From: Julia Davies [REDACTED]
Sent: 18 October 2018 12:17
To: Planning
Subject: Little Glebe, Fontwell (AL/111/18/HH)

Further to your emailed letter dated 11th October, please find attached copies of revised drawings P01a, P03a and P04a, together with new drawing P05.

Drawing P04a Sept 2018 Scale 1:100, 1:500 & 1:1250 @ A2
Planning Drawing - Roof Plan, Block Plan & Location Plan

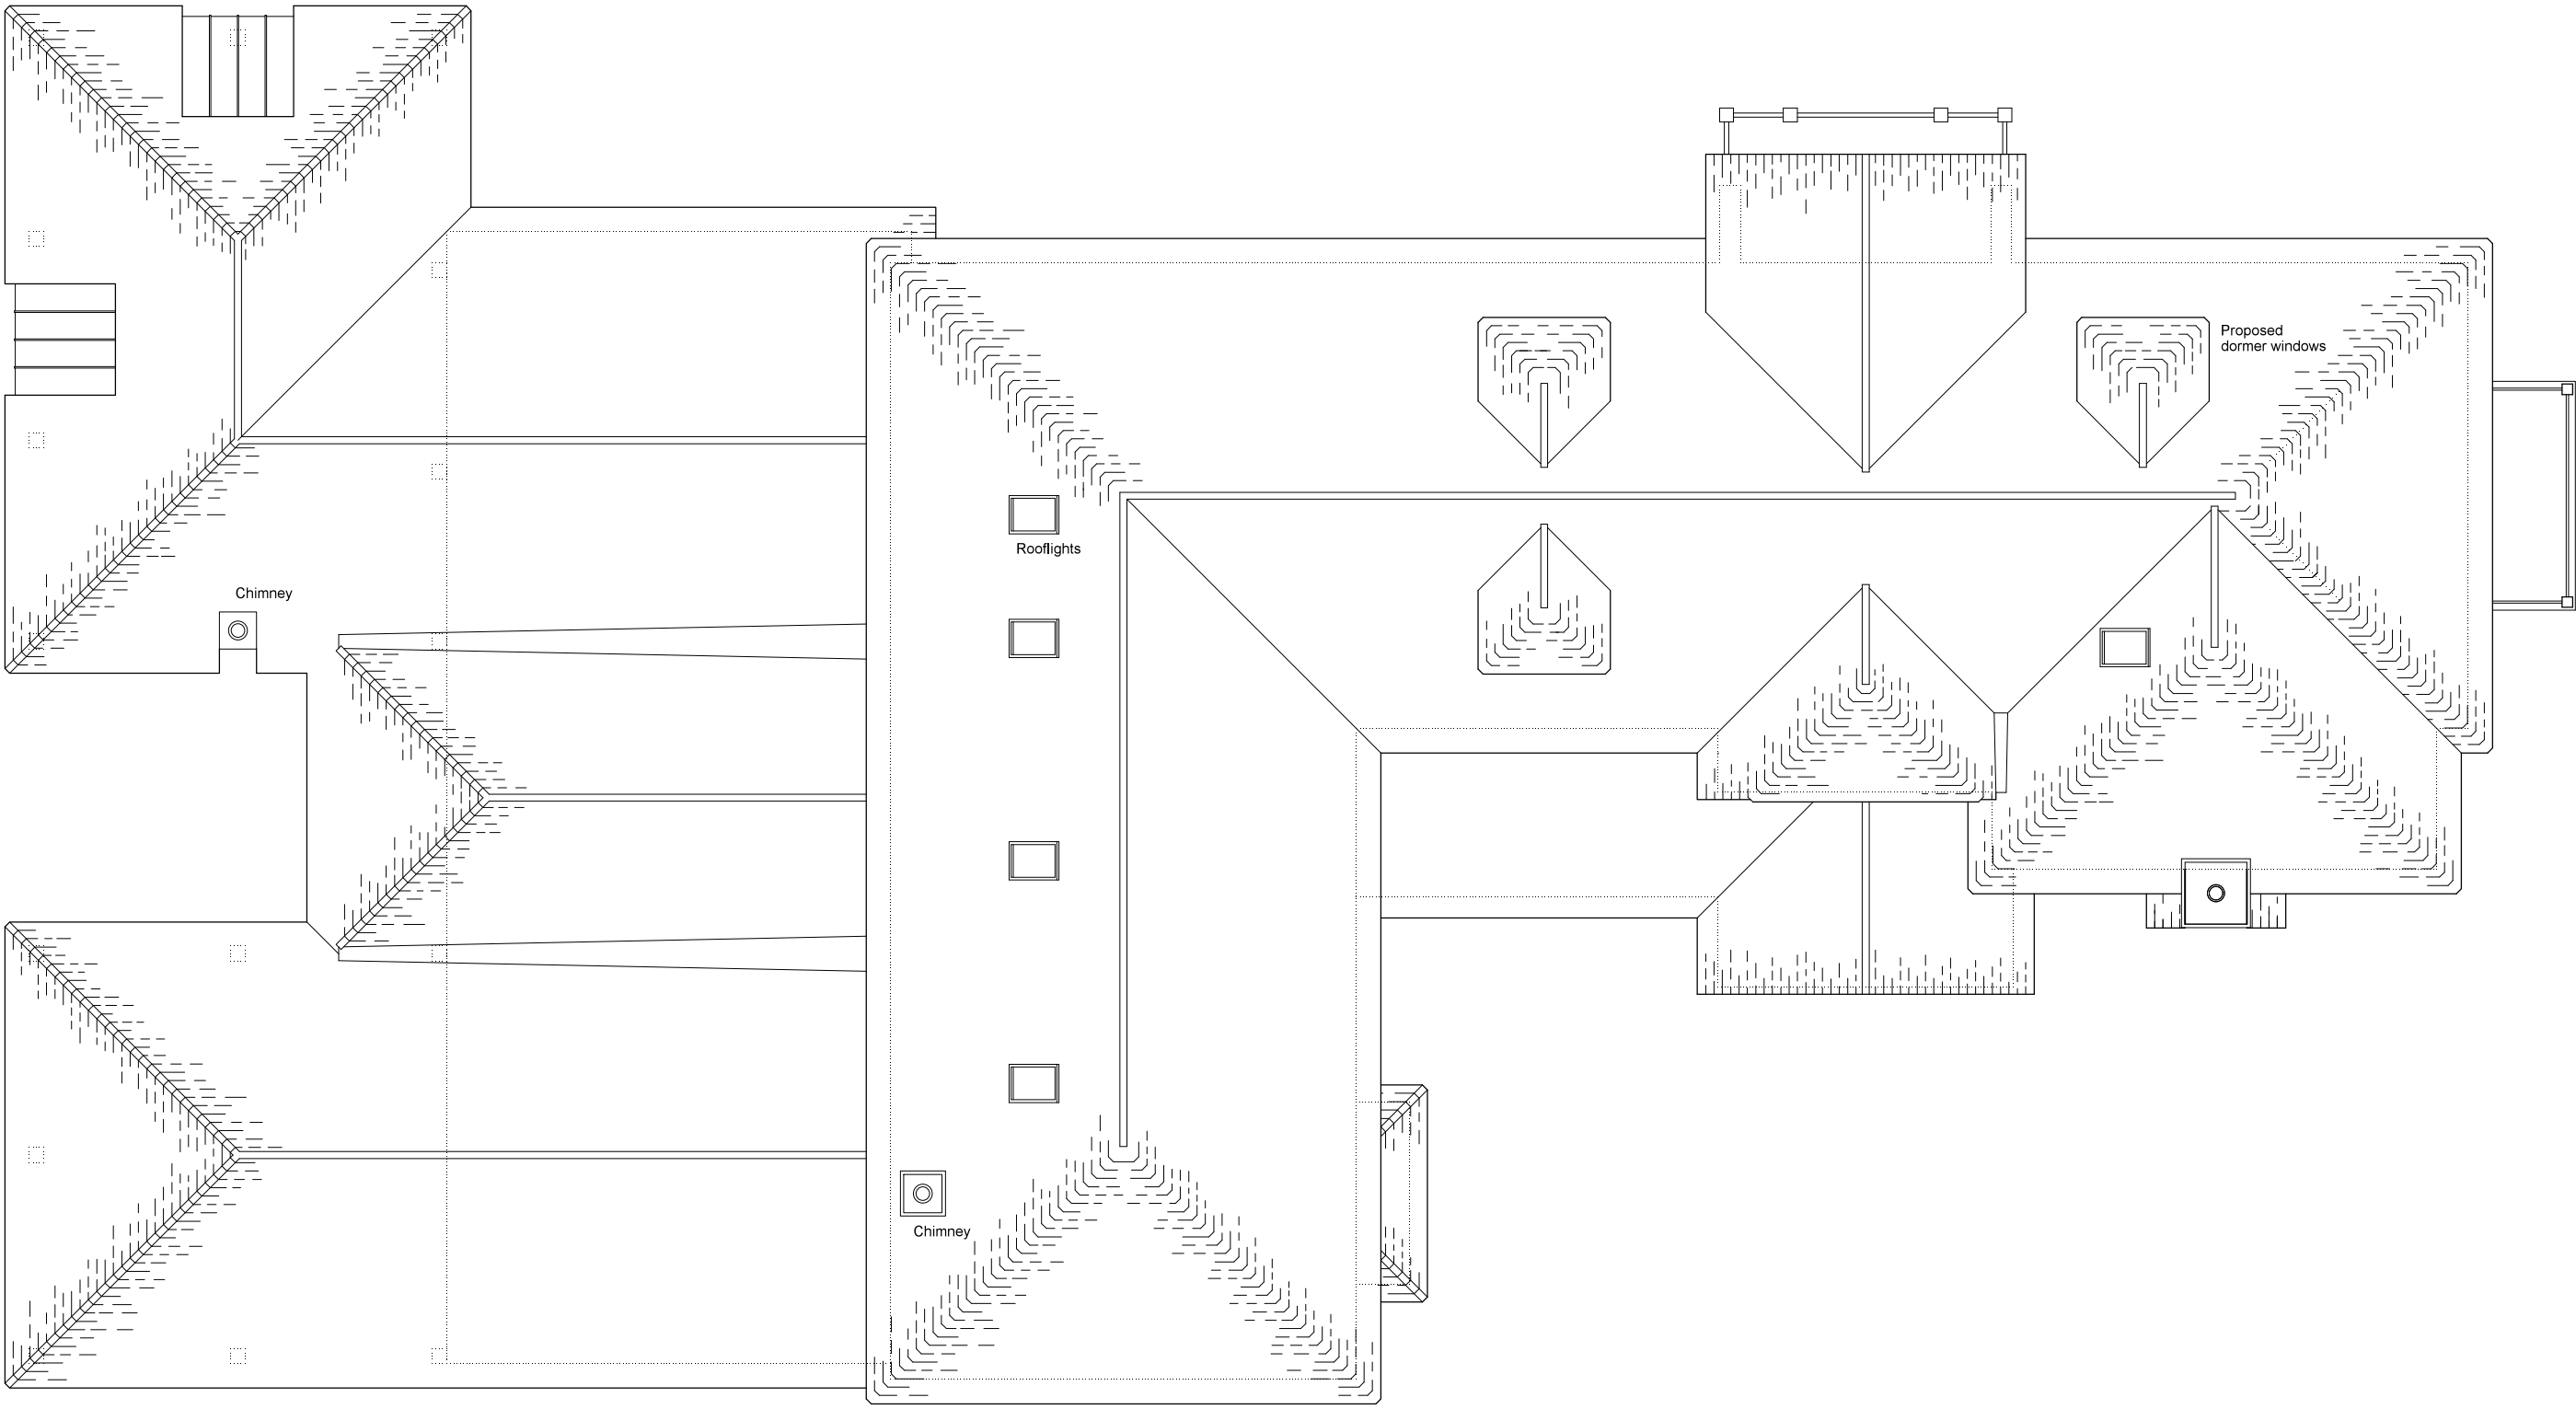
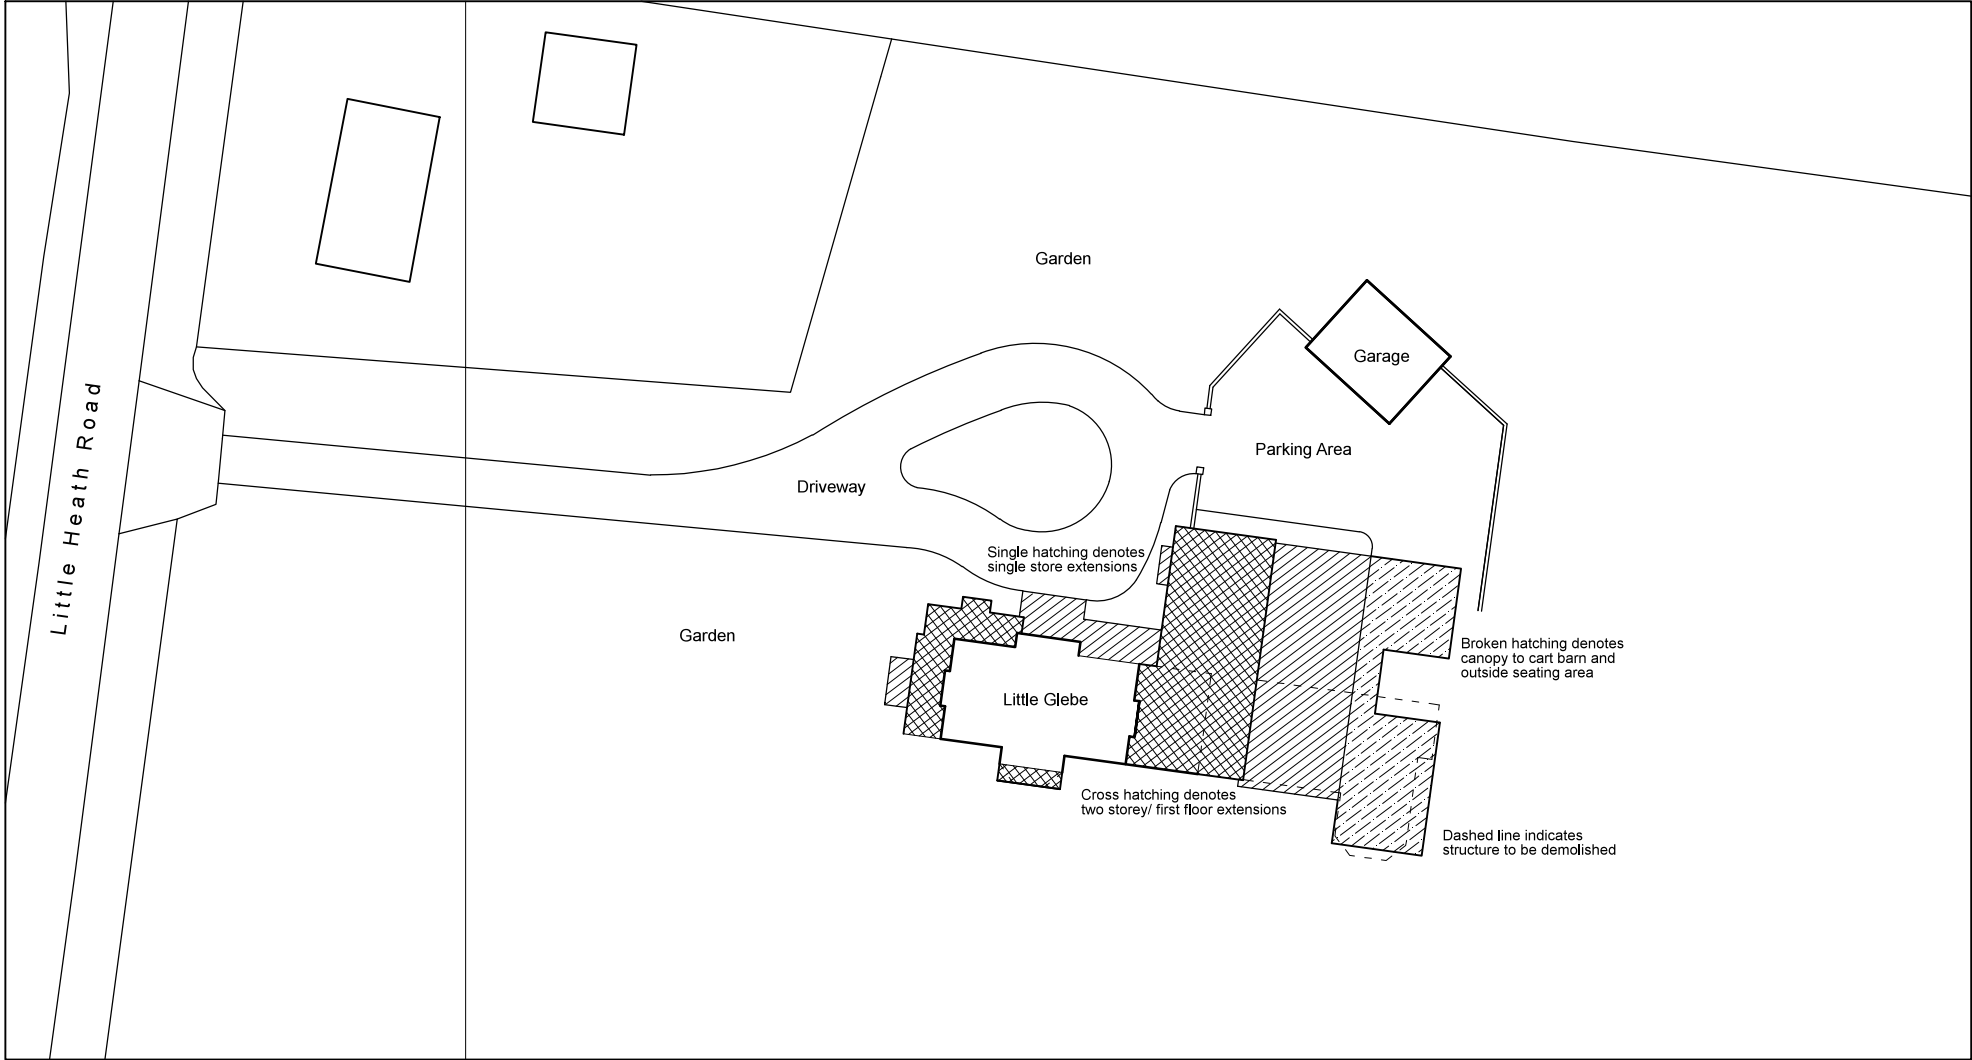
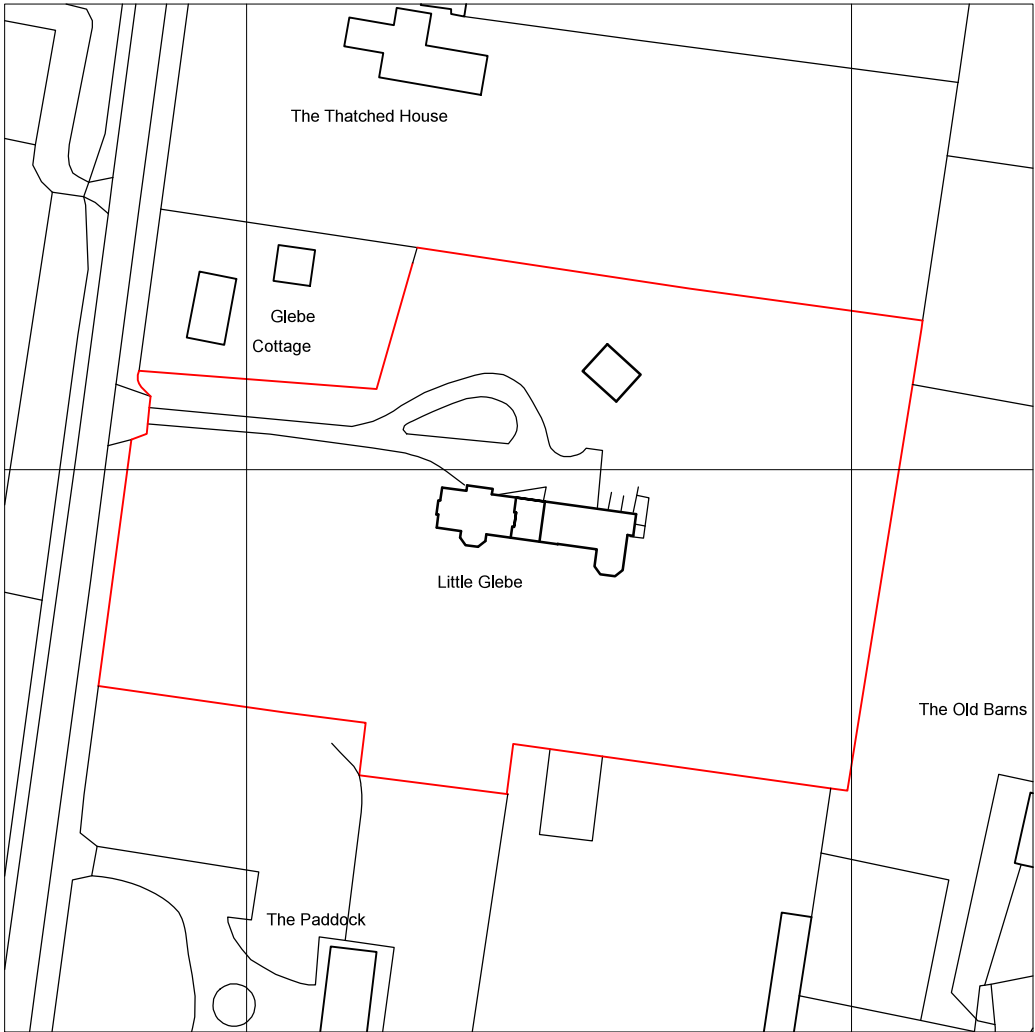
Plans

Drawings P01a, P03a and P04a have been revised to show the correct roof configuration and omitted window on the west elevation.

Drawing P05 September 2018 Scale 1:500 @ A3
Planning Drawing - Site Plan

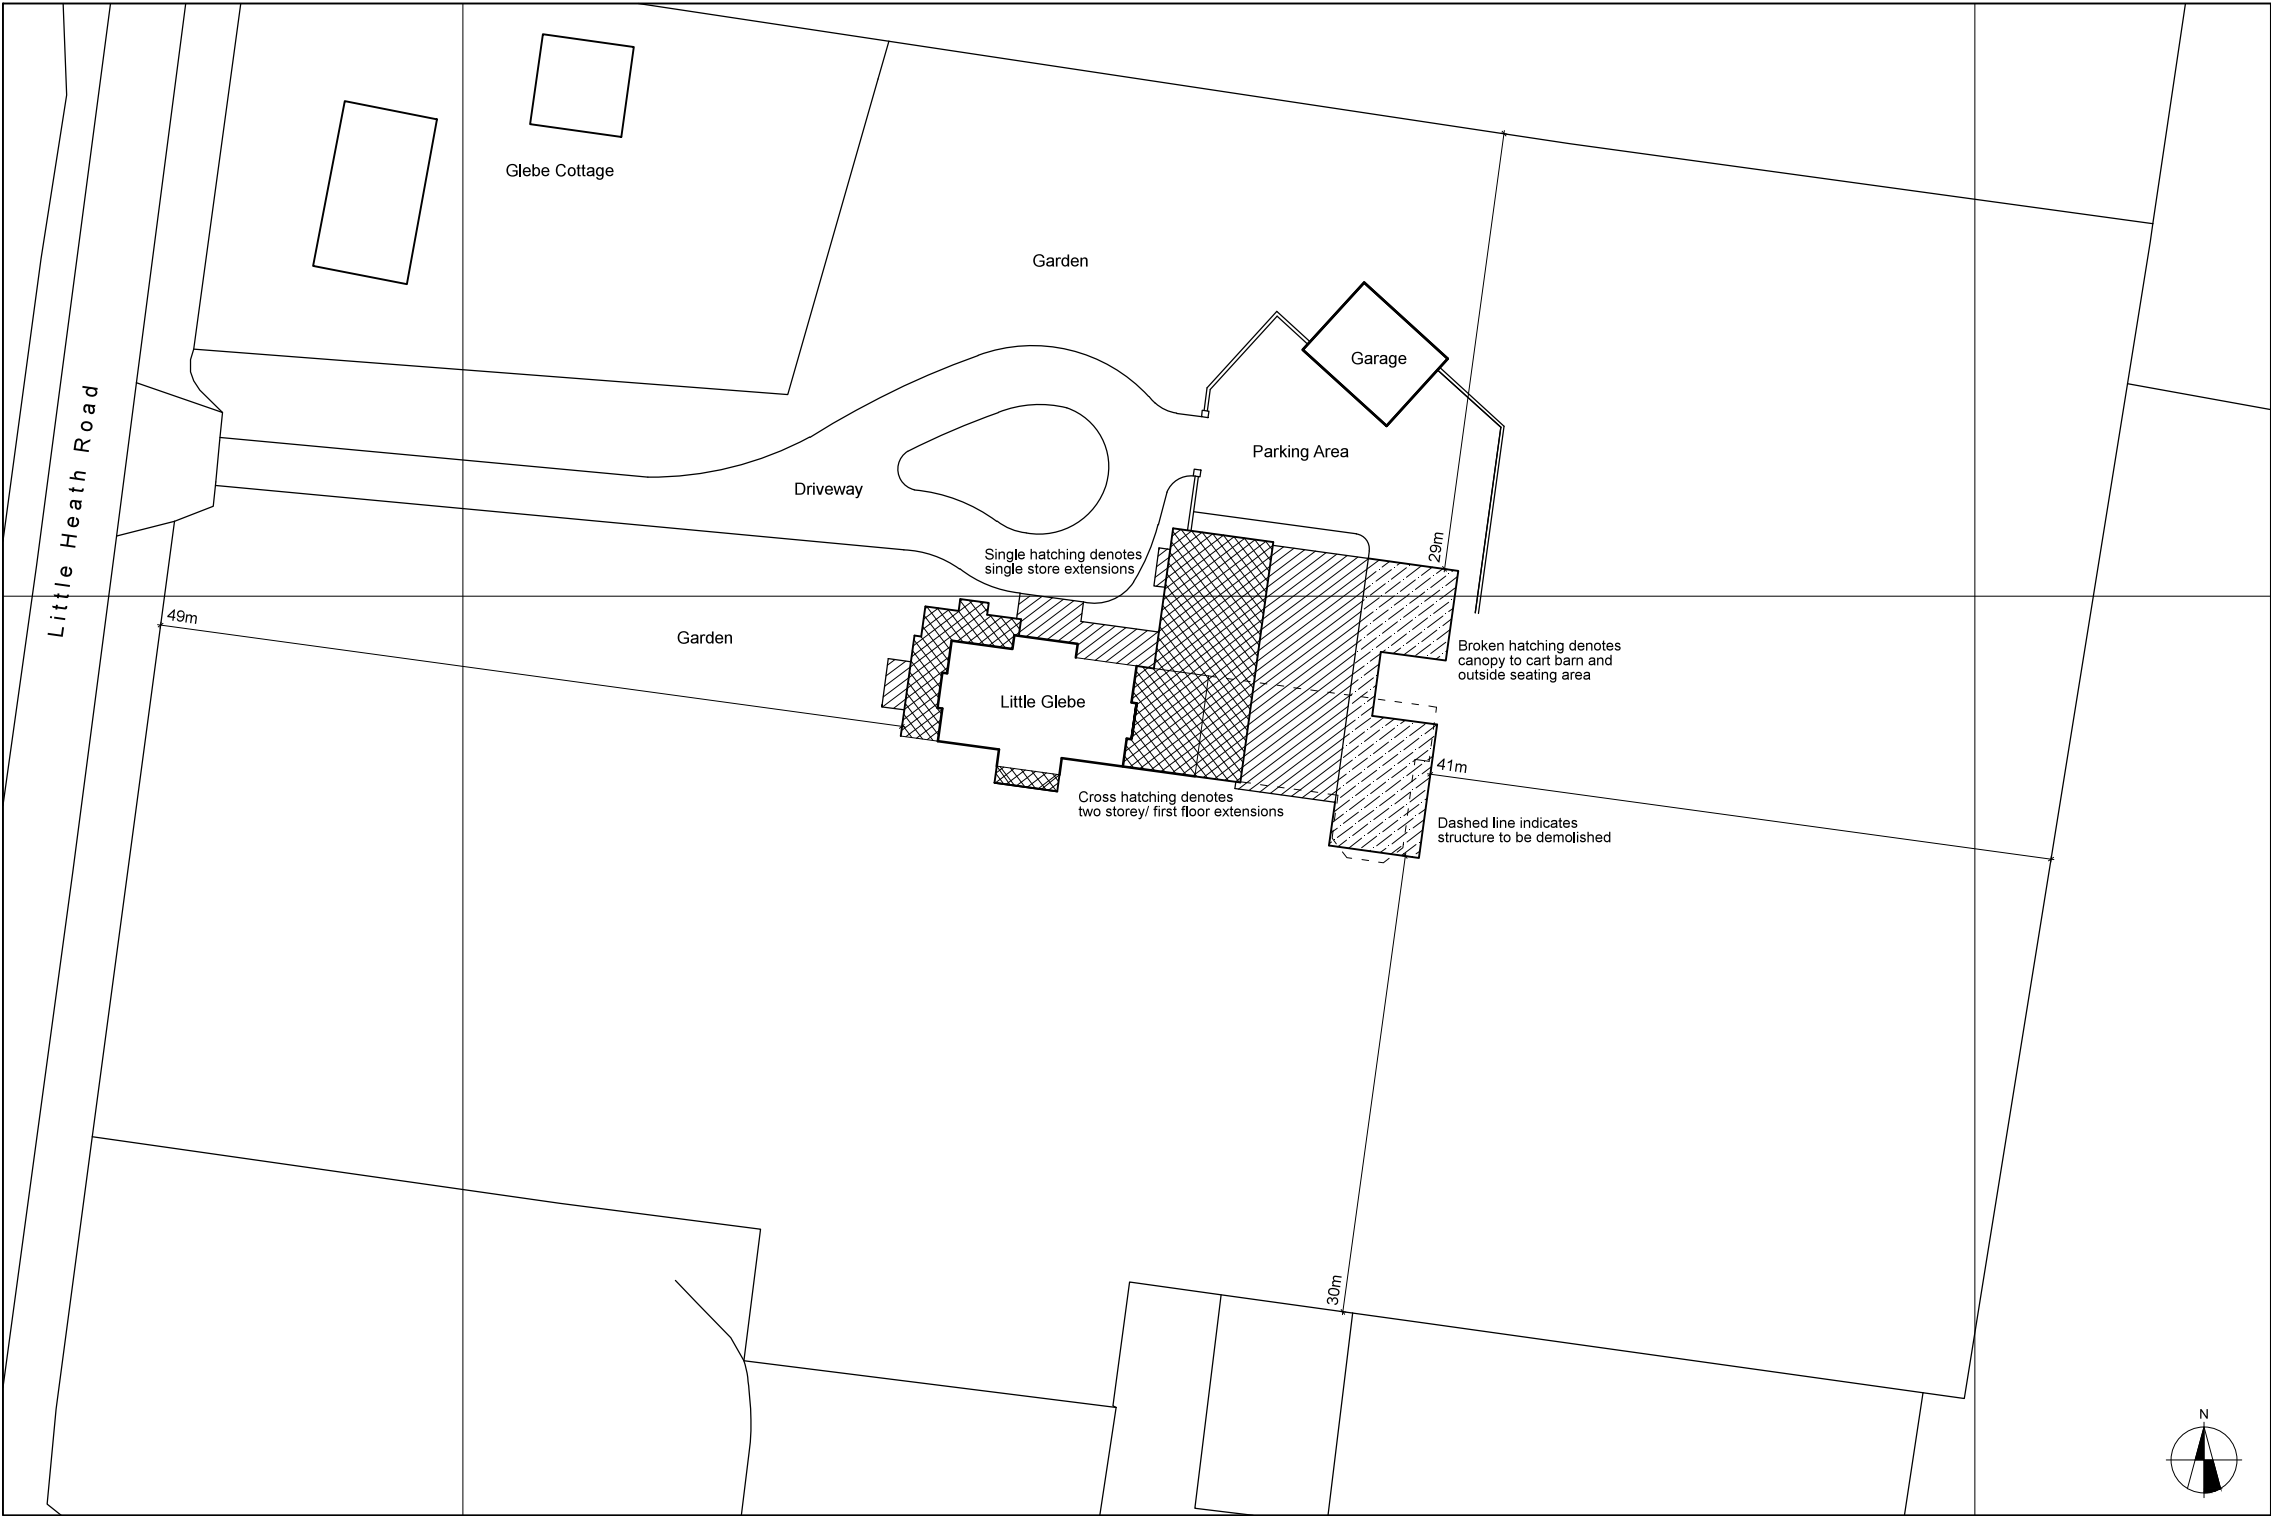
Block Plan

Please refer to drawing P05 which shows a site plan with distances to all boundaries annotated.
